From: Simon Davis
Sent: 01 October 2019 15:55
To: [REDACTED]
Subject: FW: AW/237/19/PL Former Ship Inn

From: Alison Meeus [REDACTED]
Sent: 01 October 2019 14:23
To: Simon Davis <Simon.Davis@arun.gov.uk>
Subject: RE: AW/237/19/PL Former Ship Inn

Title
Site Location Plan with Vehicle Tracking : Articulated Vehicle

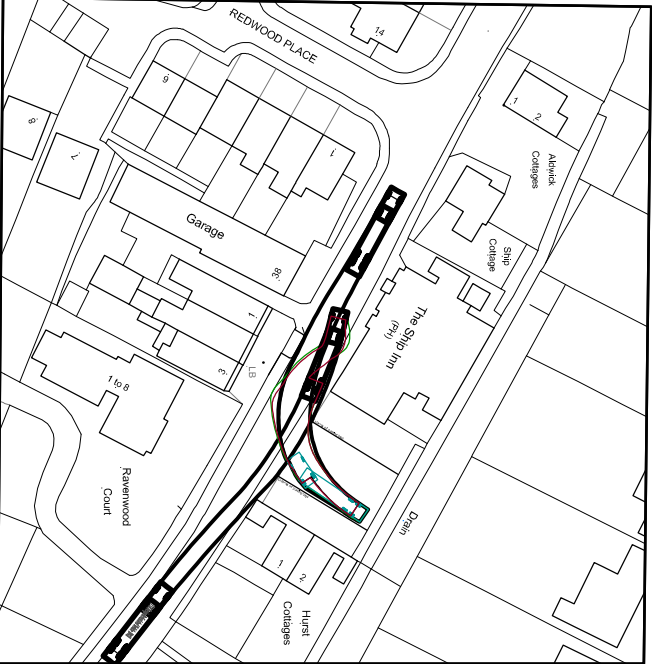
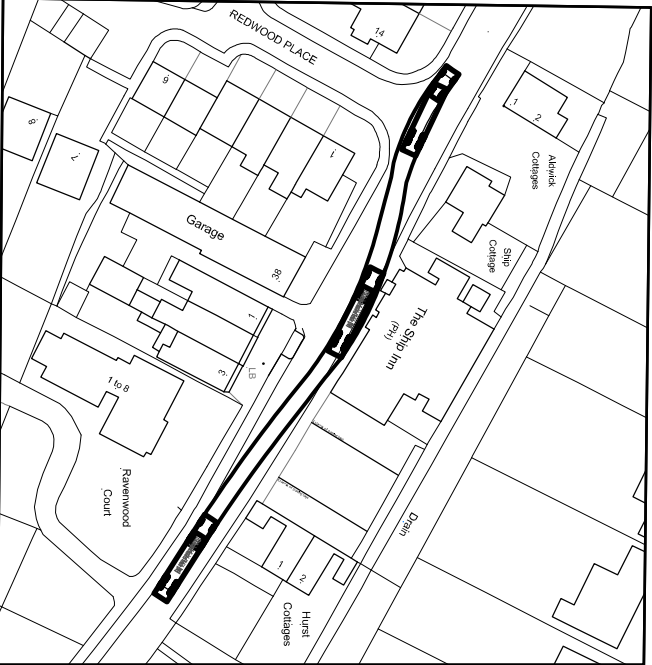
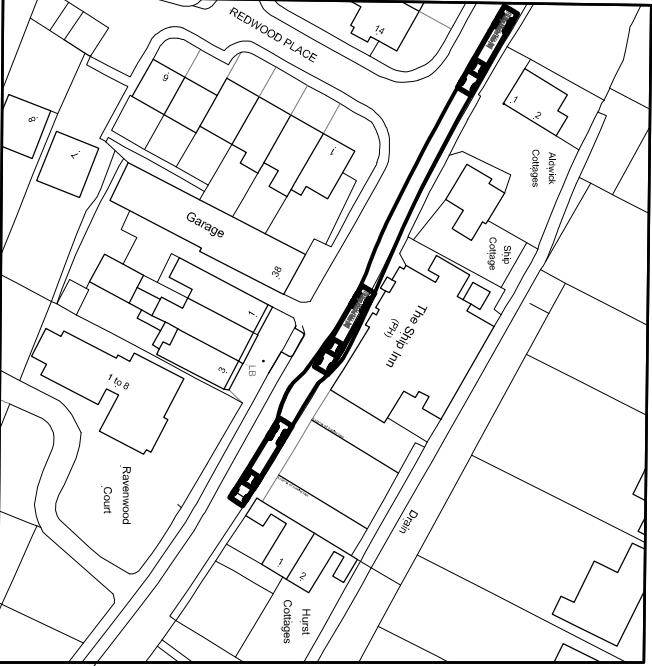
please can you include a swept path of a car using the highway at the same time the loading area is in use.

6)Although the swept path diagrams take into consideration the build out, there are also improvements to the northern section of highway. It is noted that the location of the HGV would stop the informal crossing being used. Is there room for the delivery vehicle to keep clear of this at all?
